**Engineering Review**

**WATERMARK AKERS DRIVE**  
Traffic Impact Study

## SITE DEVELOPMENT PLAN

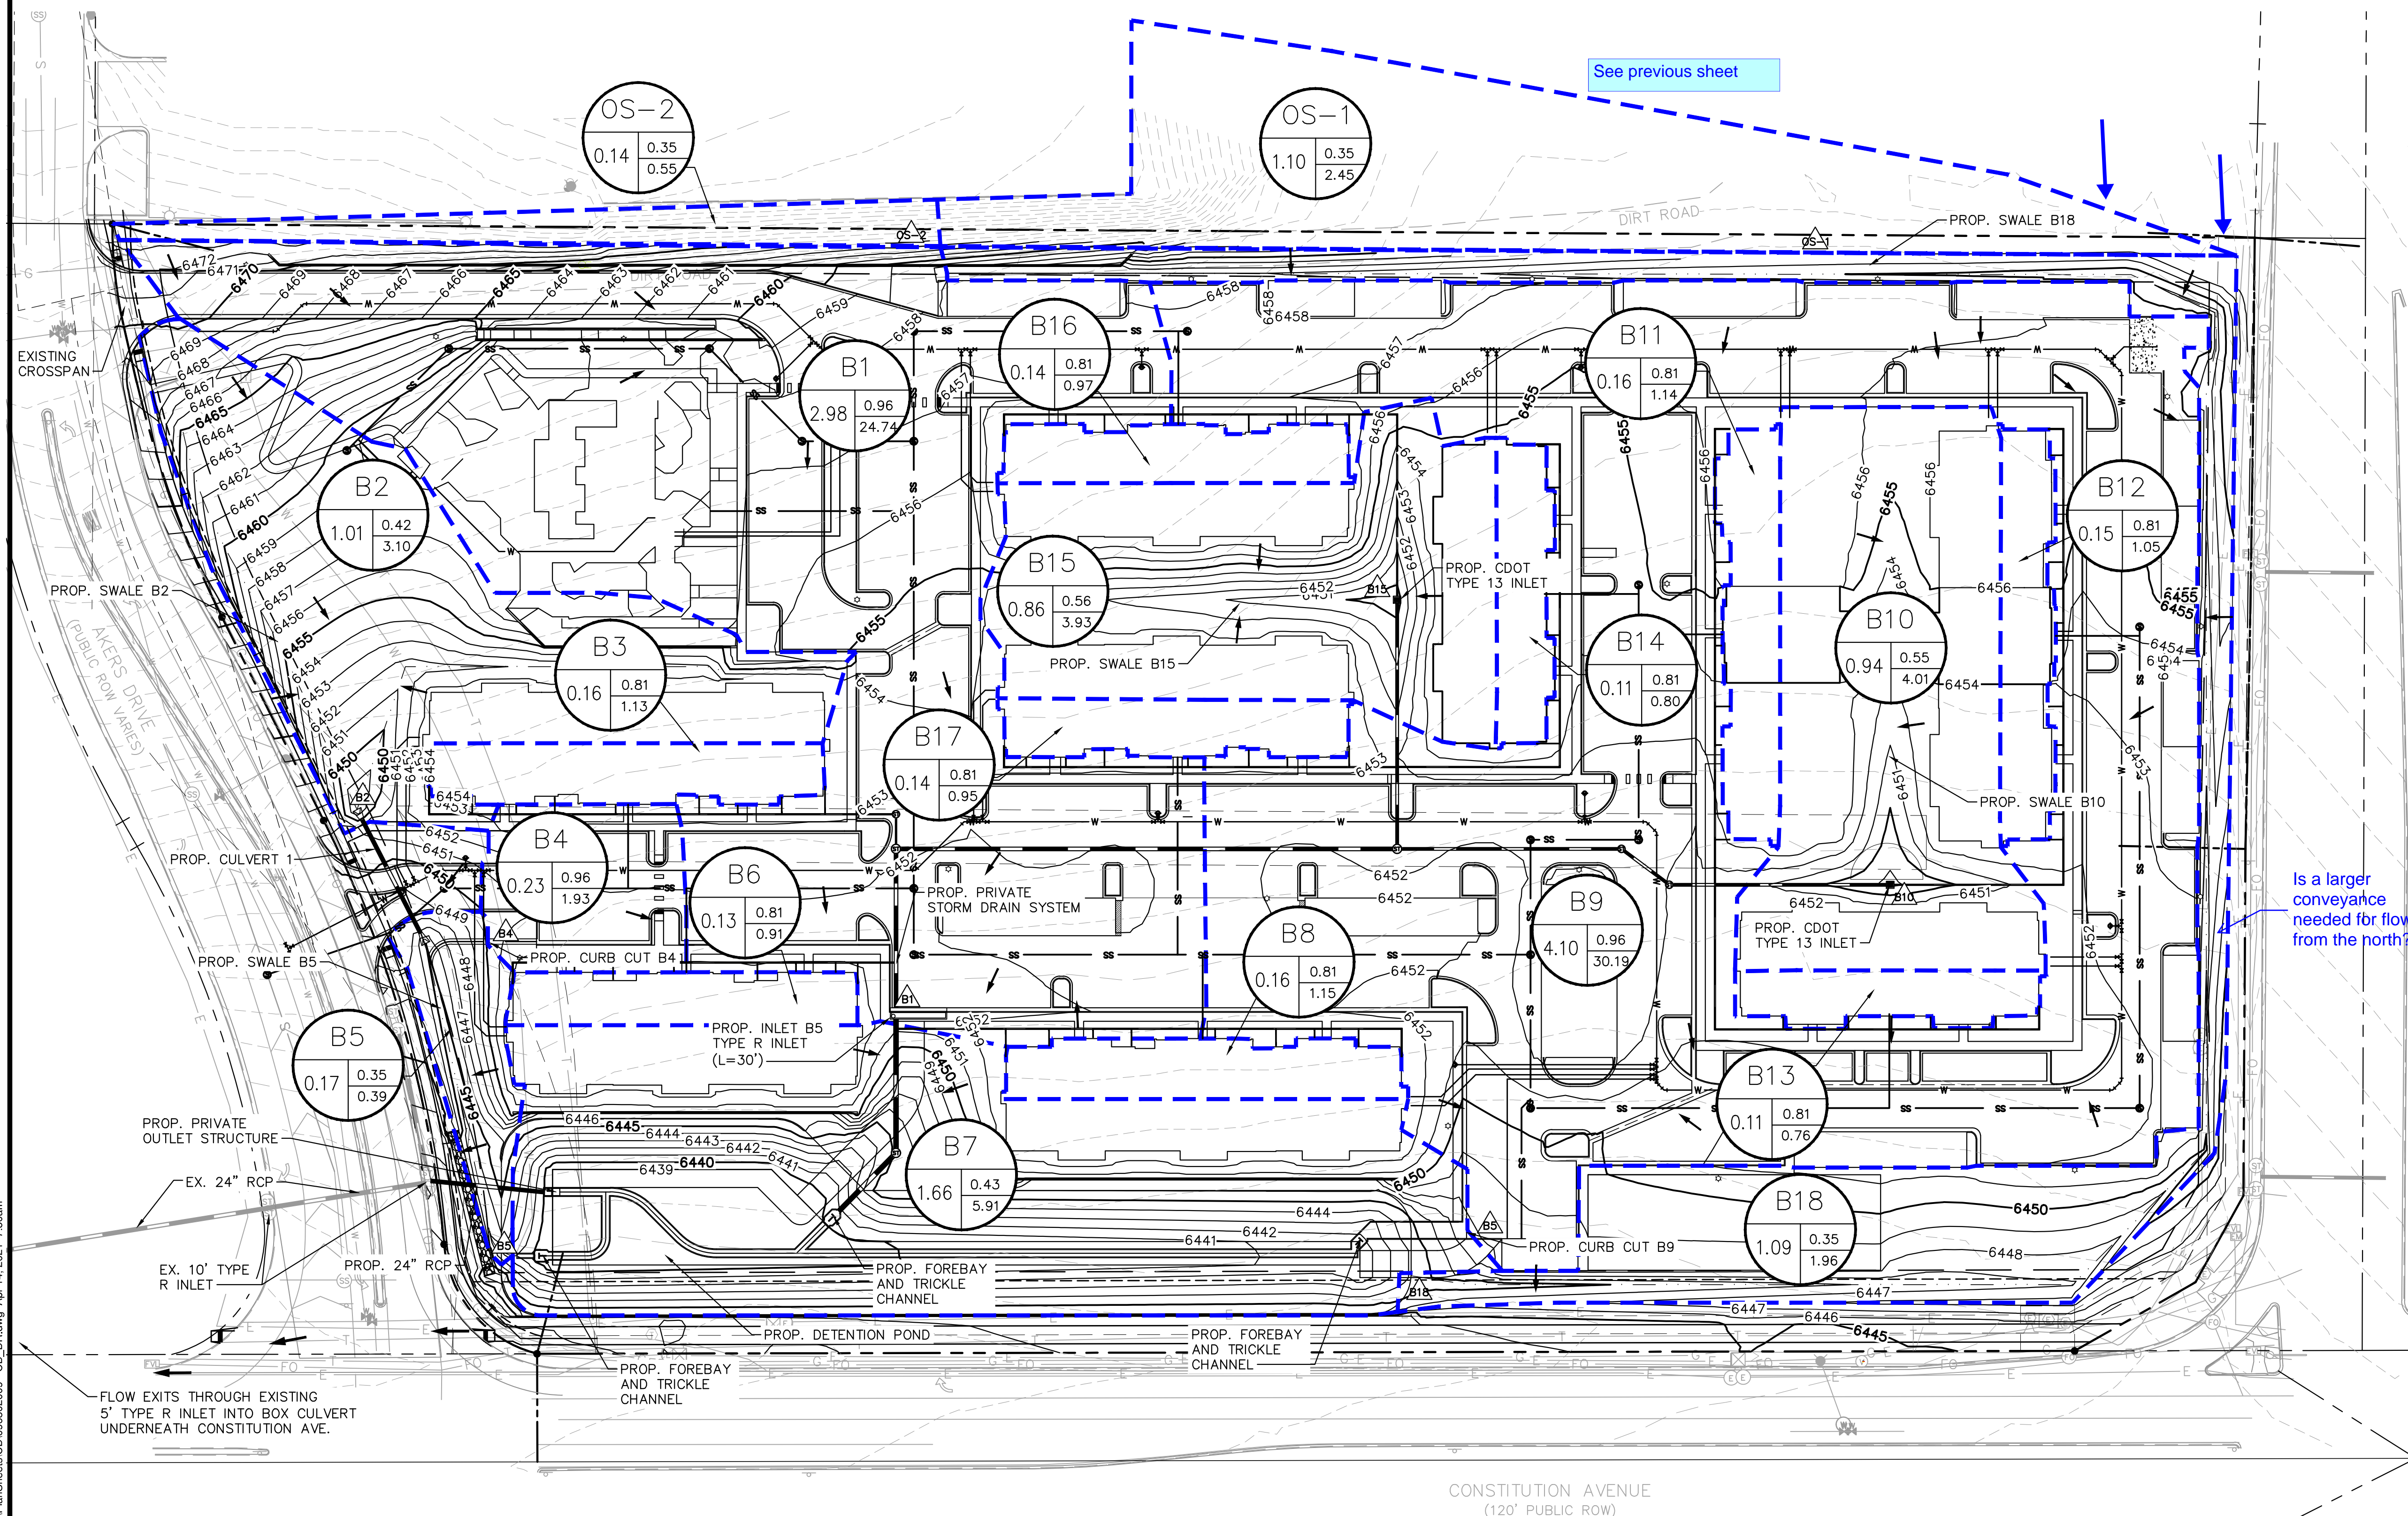
Provide a Transportation Memorandum referencing the approved TIS and addressing the access issues. Also state whether the owner will select inclusion into a specific PID district or just pay the Road Impact Fee at building permit.

Provide an exhibit showing distances between access points/intersections and sight distances

Provide a table or discussion comparing ECM requirements to proposed.
